**STATE SIGNIFICANT DEVELOPMENT:
Section 96(1A) Modification Application**

AUSTRALIAN TECHNOLOGY PARK, EVELEIGH

SSD 7317 MOD 4

Environmental Assessment Report
Section 96(1A) of the *Environmental Planning
and Assessment Act 1979*

Roof Plan

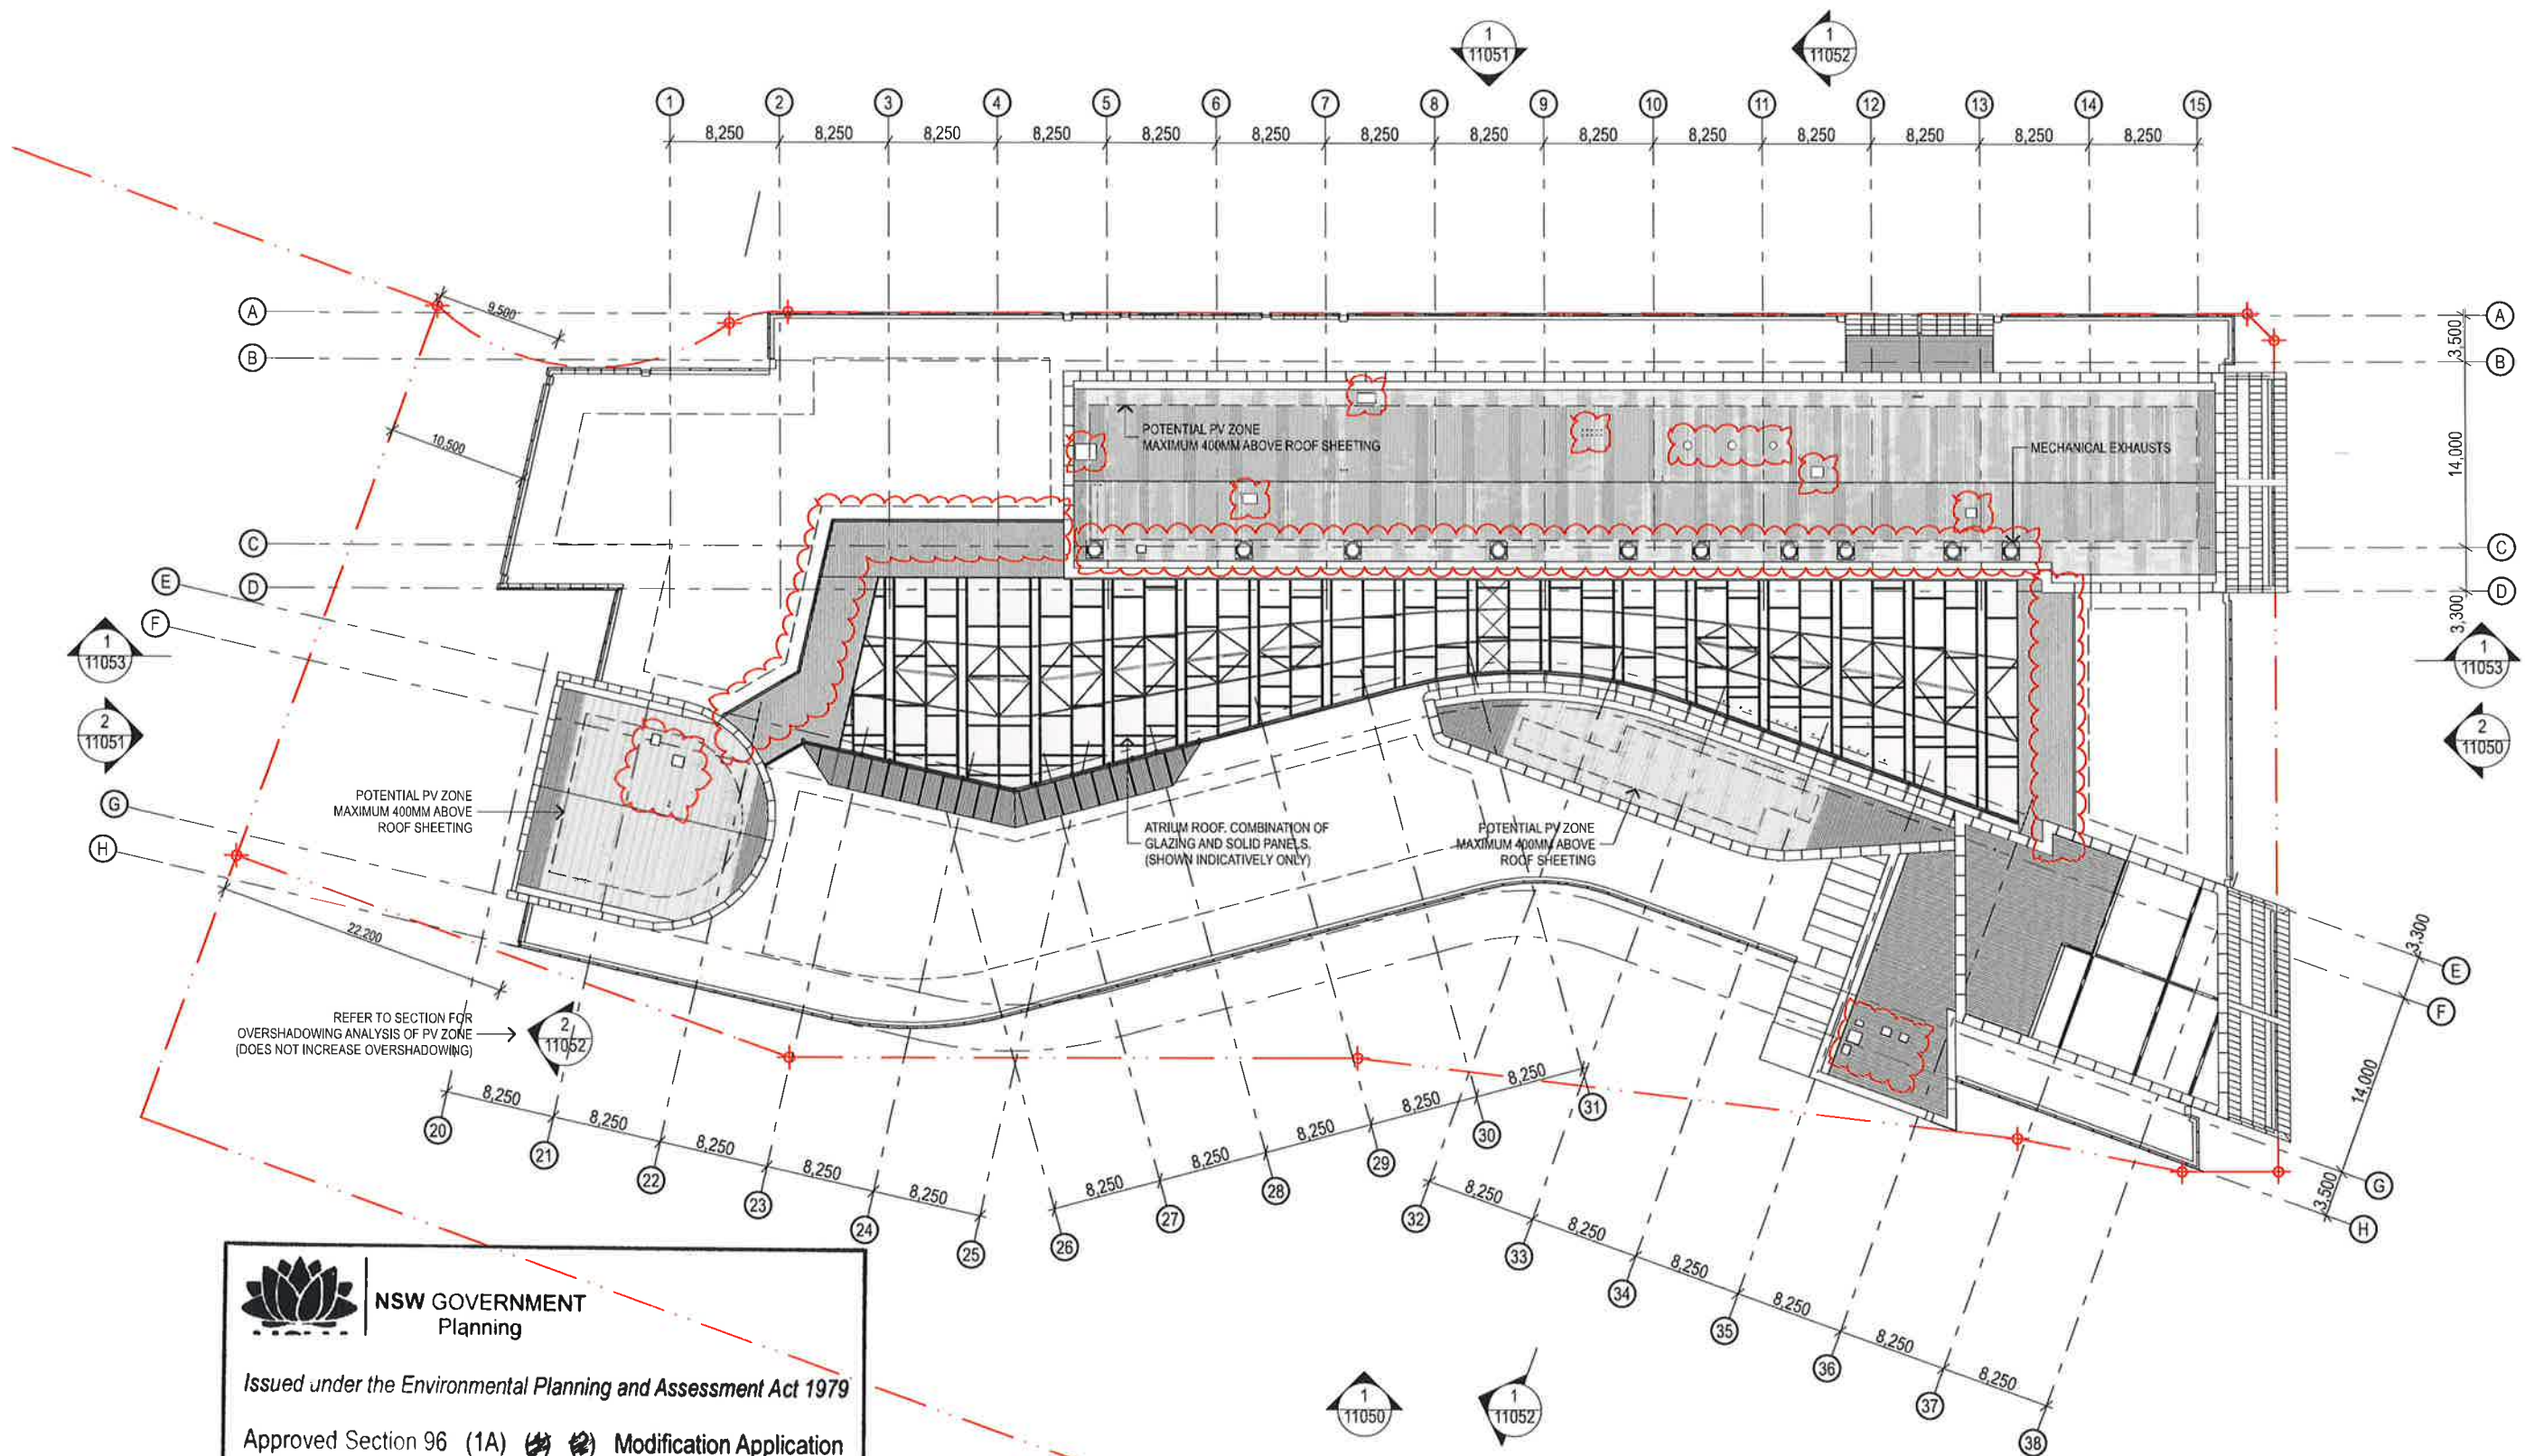
The proposal seeks approval to install mechanical exhausts, flues, vents and photovoltaics, which will protrude between 0.4 and 3 m above the approved roof line. The majority of these will be located on the northern half of the roof and those on the southern half of the roof will be below 1 m in height above the approved roof line (**Figure 3**).

The Department notes the location of the exhausts, flues, vents and photovoltaics is not uniform across the approved roof of the building and are set back from the building edge a minimum of 5 m for the exhausts, flues and vents, and 2 m for the photovoltaics which minimises the visual impact from the public domain. It is likely these elements will be imperceptible when read in the context of the whole building. The Department therefore considers these elements are acceptable in design terms and that the overall design quality of Building 1 will be maintained.

Sheet No. 3 of 4

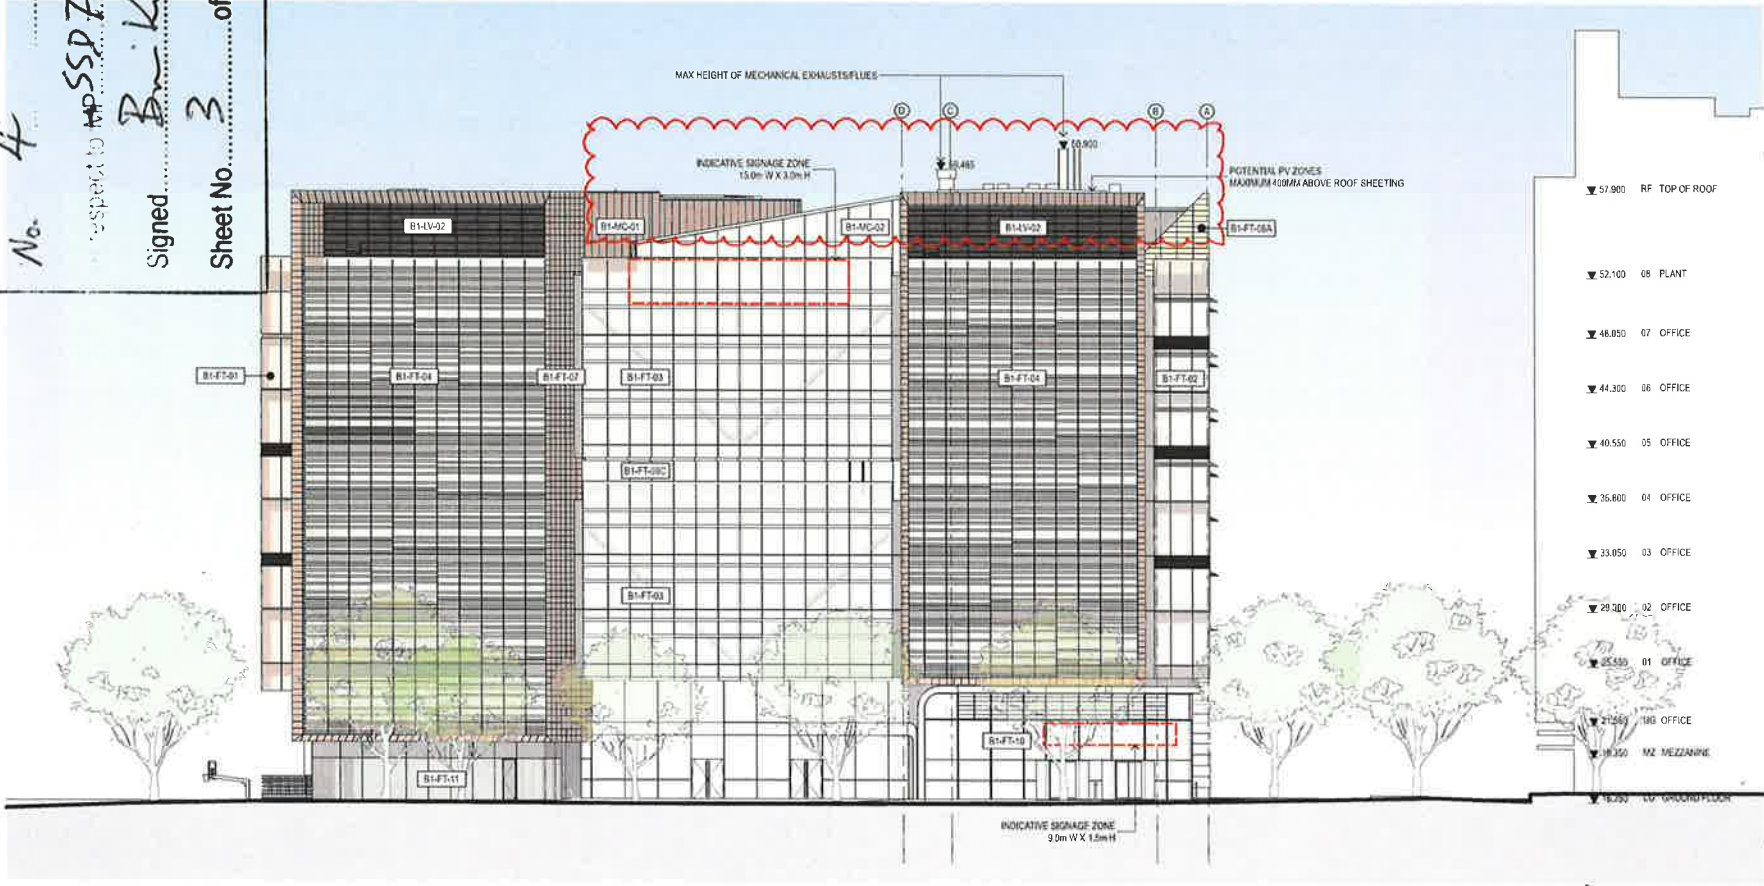
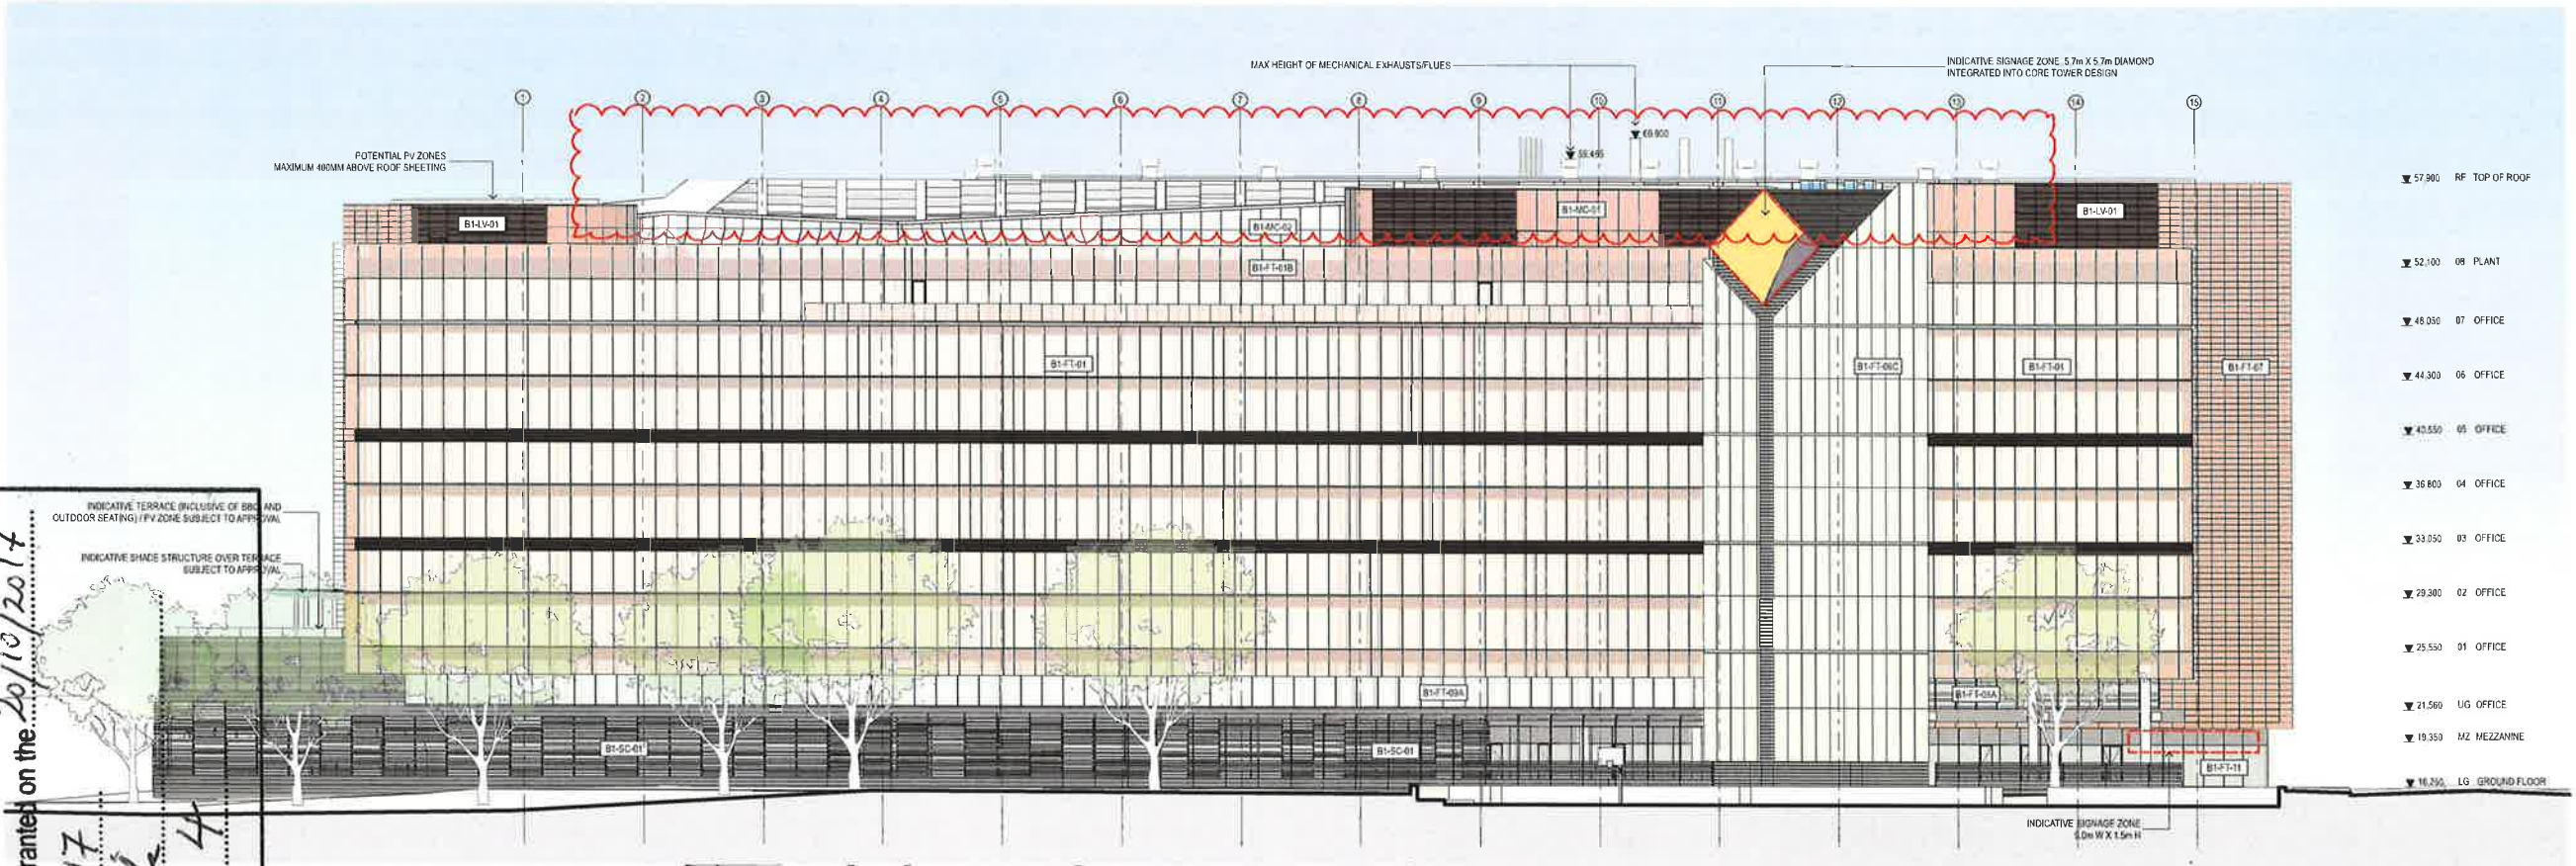
The Applicant states that the flues and photovoltaics have been restricted to the minimum height possible and positioned in plan to ensure their visual impact on the public domain is limited. As each of these elements is positioned away from the roof edge, the acute sightline from street level prevents any of the flues or photovoltaic cells from being seen at street level.
